PORTLAND MAINE

September 4, 2007

RE: 88A (Rear) Winter Street – 045 E055 – R-6 – enclosing screened porch – permit # 07-1066

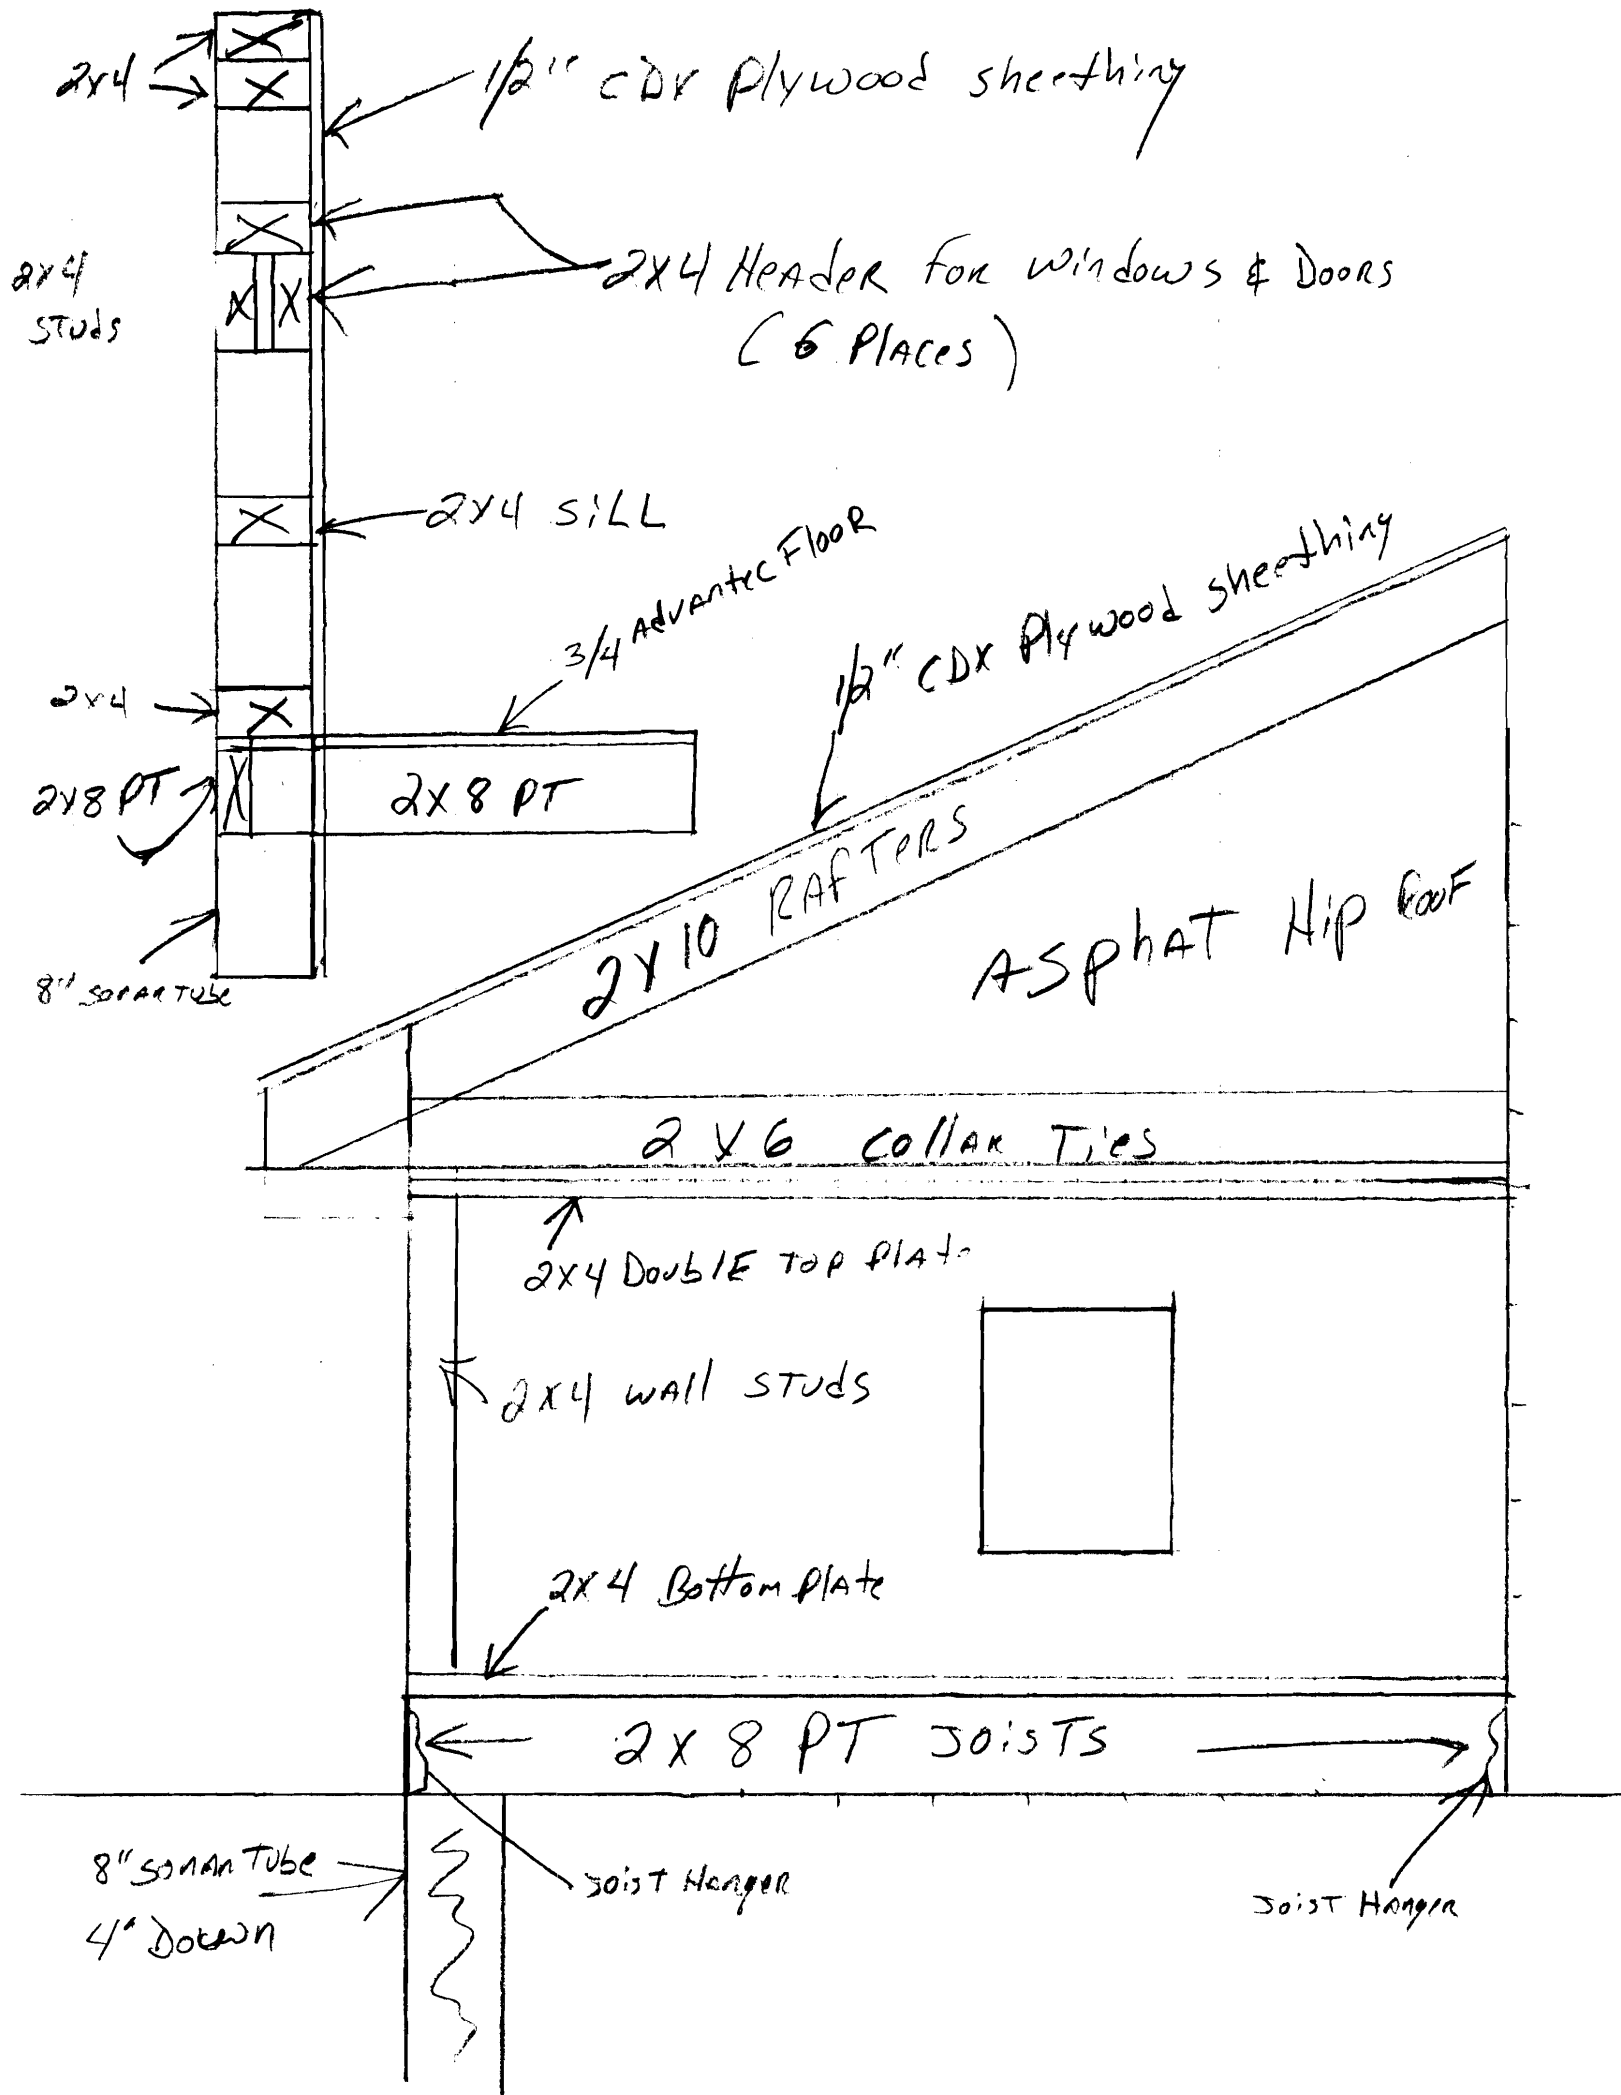
I am in receipt of your application to remove the existing covered porch and replace it with a new enclosed porch at your property at 88A Winter Street. Your property is located in the R-6 residential zone. The ordinance in section 14-139(d)(1) gives the minimum required front yard setback as ten feet. The plot plan submitted with the application gives the front yard setback from the porch as three feet. The application says that the new porch is going to be in the exact footprint of the old, existing one. Since the footprint was not going to be enlarged, I checked our records to see if the existing porch had been permitted previously. I could find no record of a permit for the existing porch in our files. I also checked the assessor's records from before 1957 to see if the porch had been built before the ordinance went into effect, but there was no porch then. Since I cannot find a permit for the porch and it does not meet the ten-foot front setback, it is not legal and you have no right to it. The porch must be brought into compliance with the present ordinance. If it cannot comply, then it must be removed.
